M54 to M6 DCO Issue Specific Hearing and Compulsory Acquisition Hearing

Written Submissions of Oral Case on behalf of Allow Limited ('Allow')

Summary of Items Raised at Issue Specific Hearing 1 'Biodiversity and Cultural Heritage' 8th December 2020

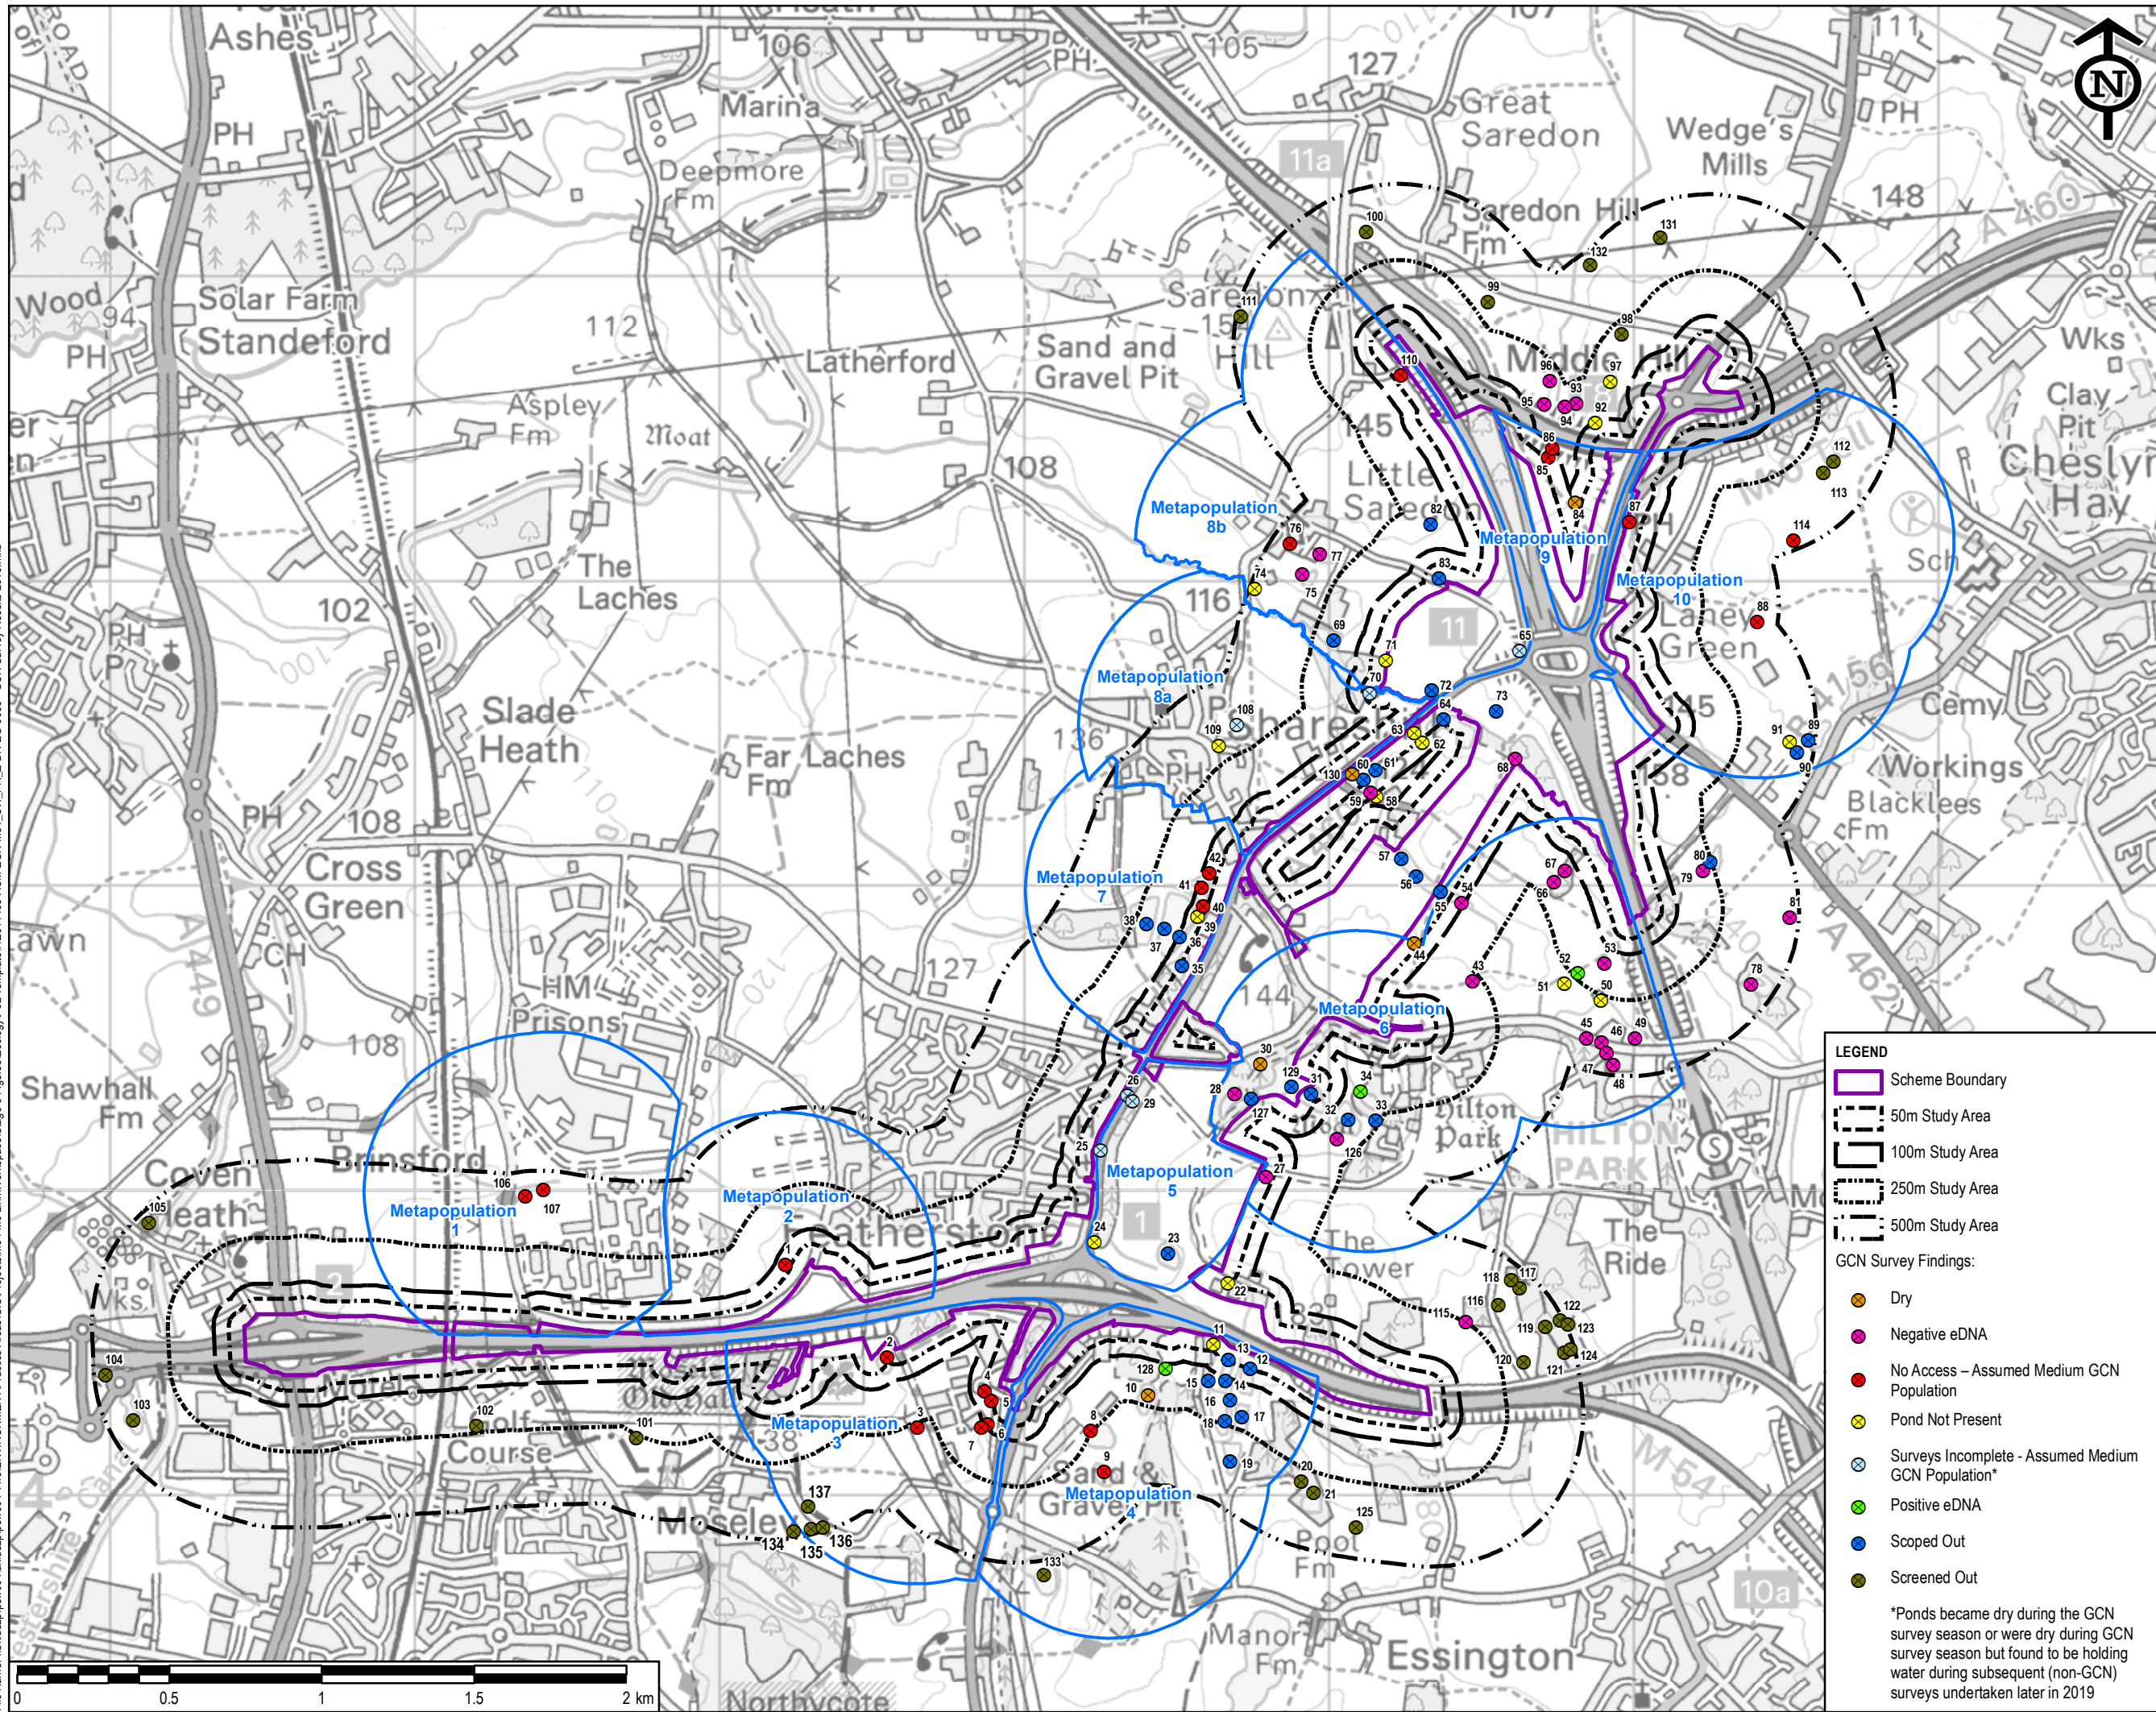
- (a) Figures 8.28 and 8.29 of the ES, plus the results obtained through the 2020 survey (Figure 8.35), show that historic, and current, known presence of Great Crested Newt is greatest to the east of the proposed scheme. However, compensatory 'ecological ponds' will be created to the west of the scheme.

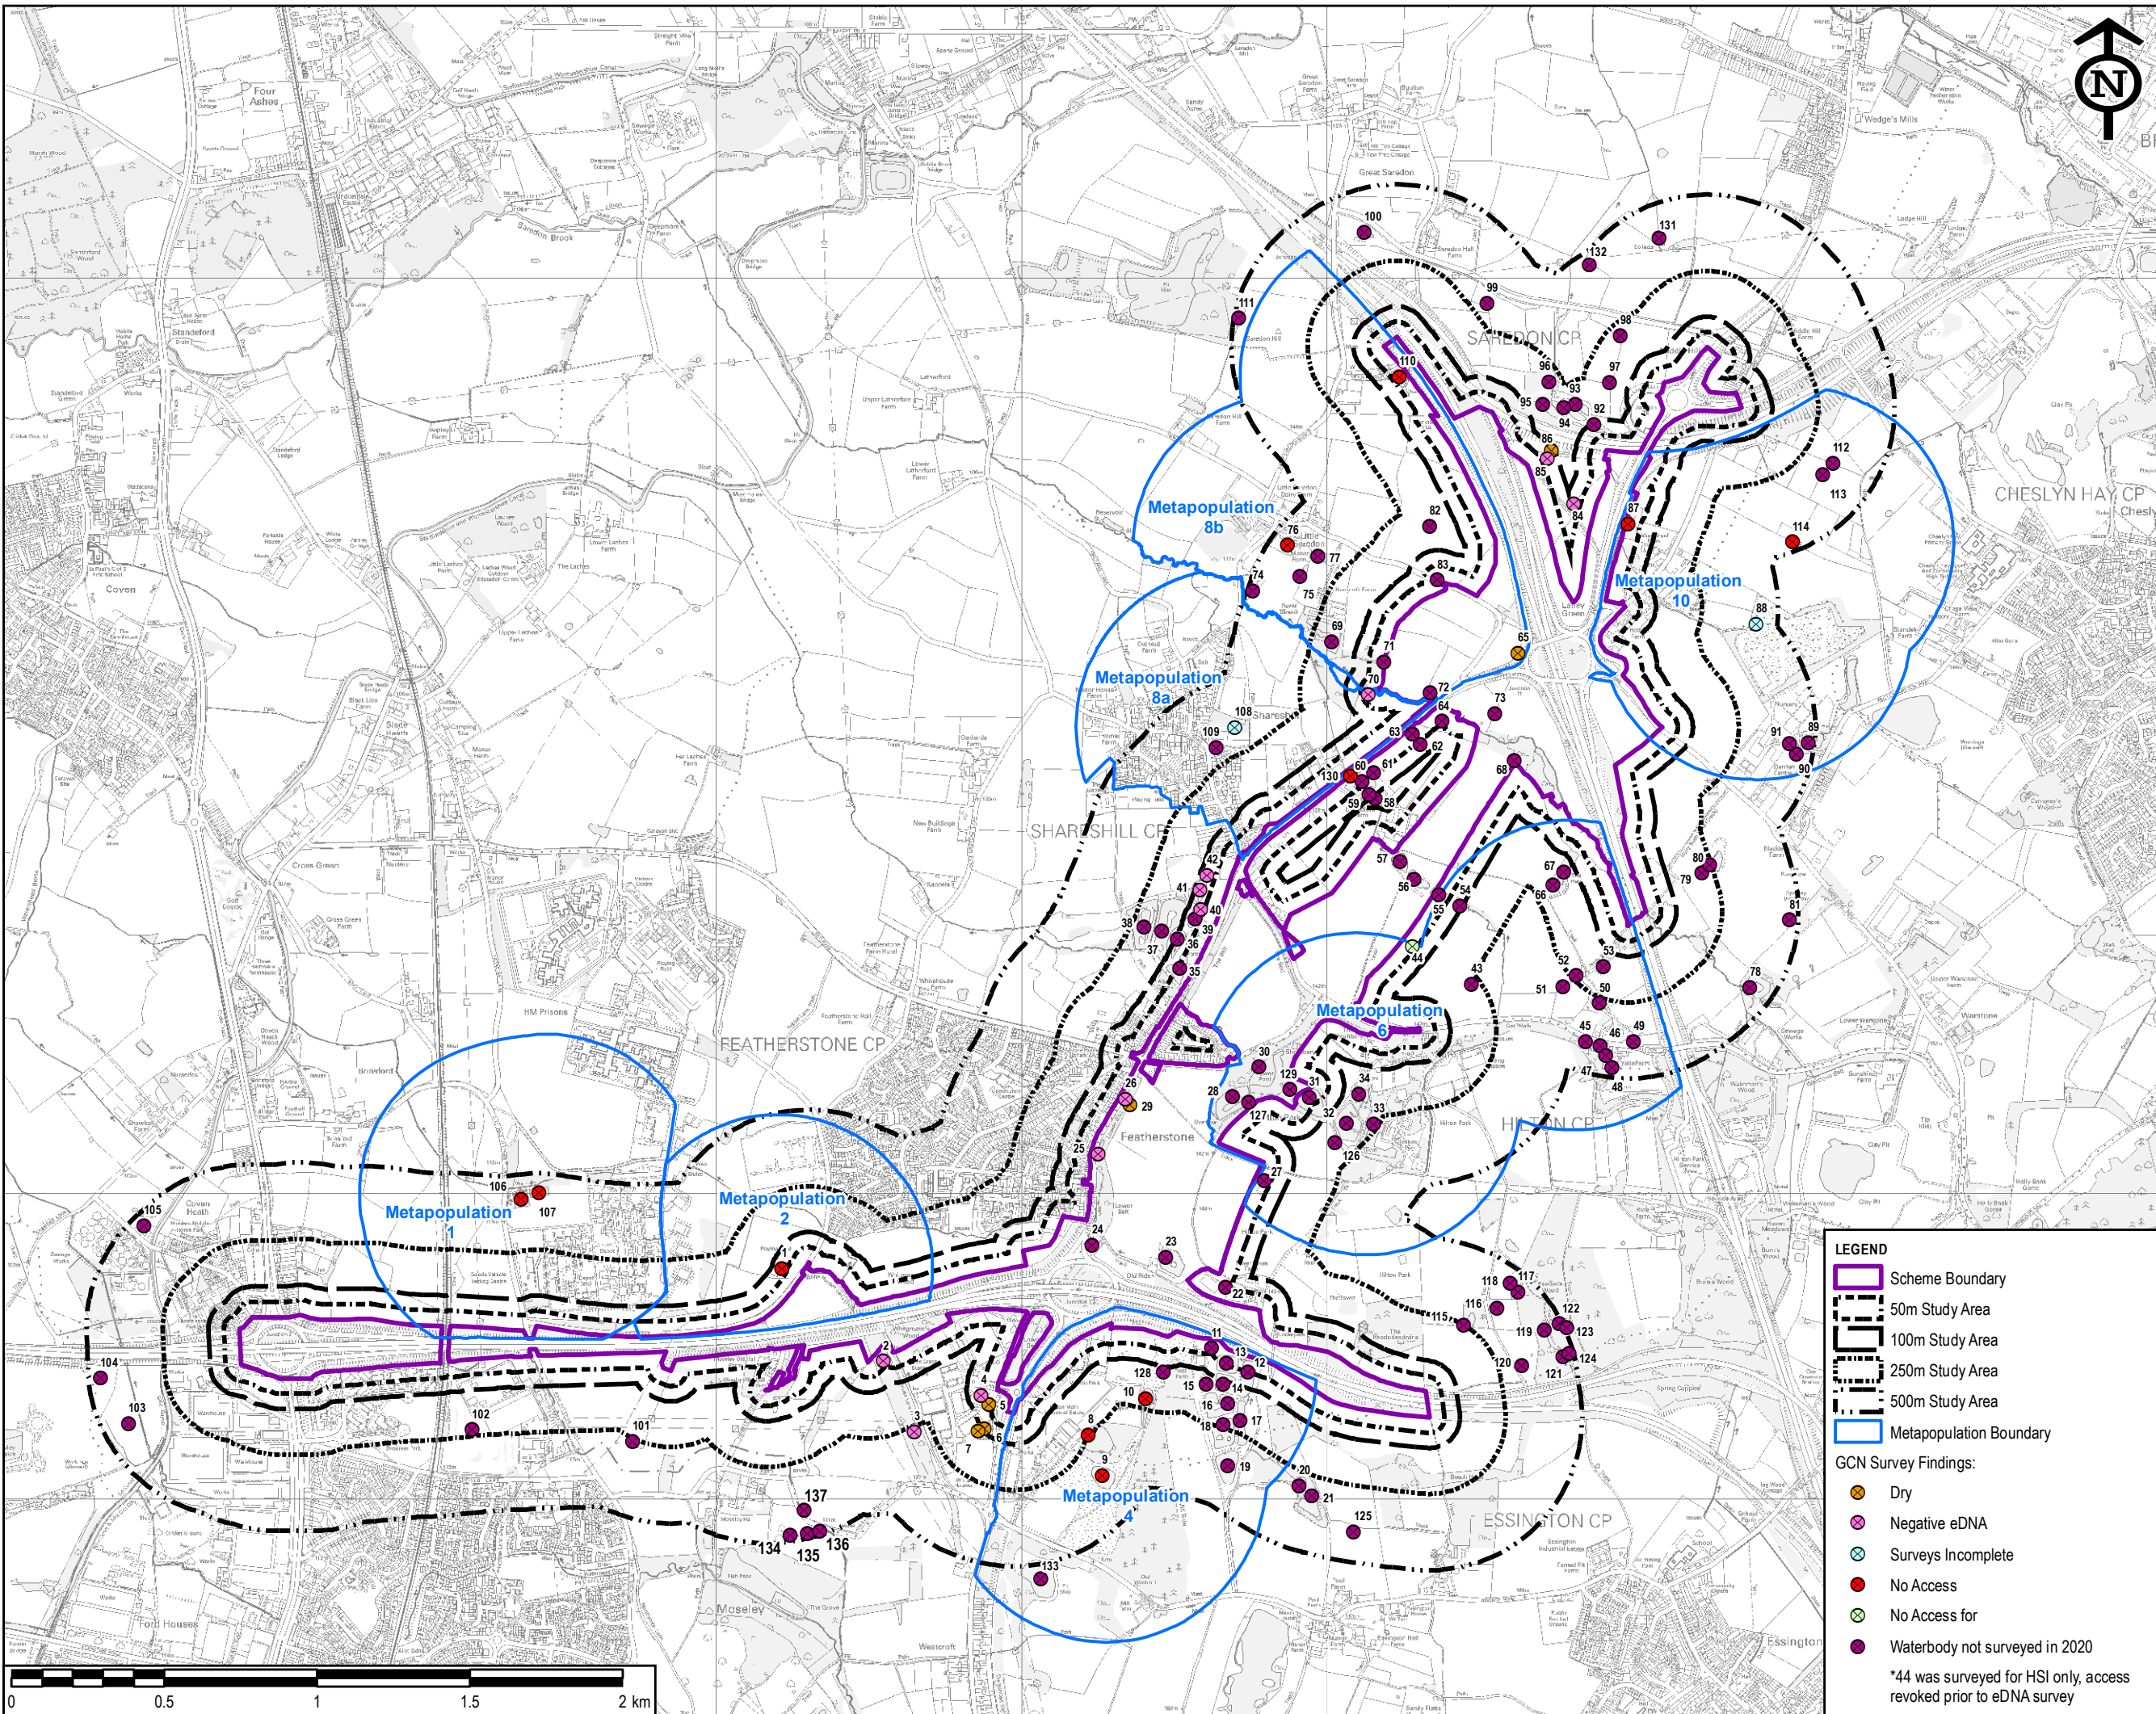
- (e) Although no specific measures for GCN on Allow's land have been proposed by the Applicant, pond 34 on Allow's land does support GCN ('Metapopulation 6' on Figure 8.35). As the majority of land within 500m of this pond is owned by Allow, a review of the draft licence Method Statement is required to determine where compensation for habitats used by Metapopulation 6 will be sited (if not on Allow's land, yet still assumed to benefit the population affected as detailed in Section 3.5.6 of the Applicant's Environmental Mitigation Approach (November 2020)).
